**New Grafton Correctional Centre – Environmental Impact Statement
SSD 7413 – Concept proposal and Stage 1 Early Works**

ATTACHMENT 1 – DETAILED COMMENTS

Figure 4-2 Irrigation Water Balance Modelling Results – Percentage of Volume Reused

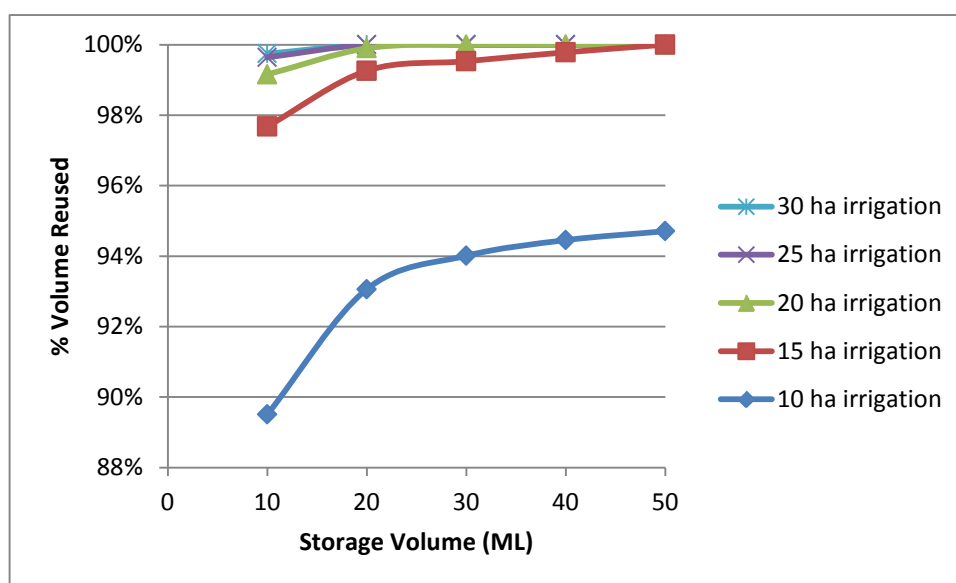
9. Appendix D Part 2, Wastewater Servicing Working Paper, Section 4.2.5 – using evaporation data from Inverell will not give a valid answer to the irrigation modelling as Inverell is climactically different to Grafton. Using such data from Inverell will overstate the evaporation. More appropriate data is from the Coffs Harbour Meteorological Officer (first choice) or

Alstonville (second choice). Daily evaporation data should have been used in the modelling as daily evaporation can be influenced by daily rainfall. The results shown in Figure 4.2 are therefore considered invalid and cannot be supported.
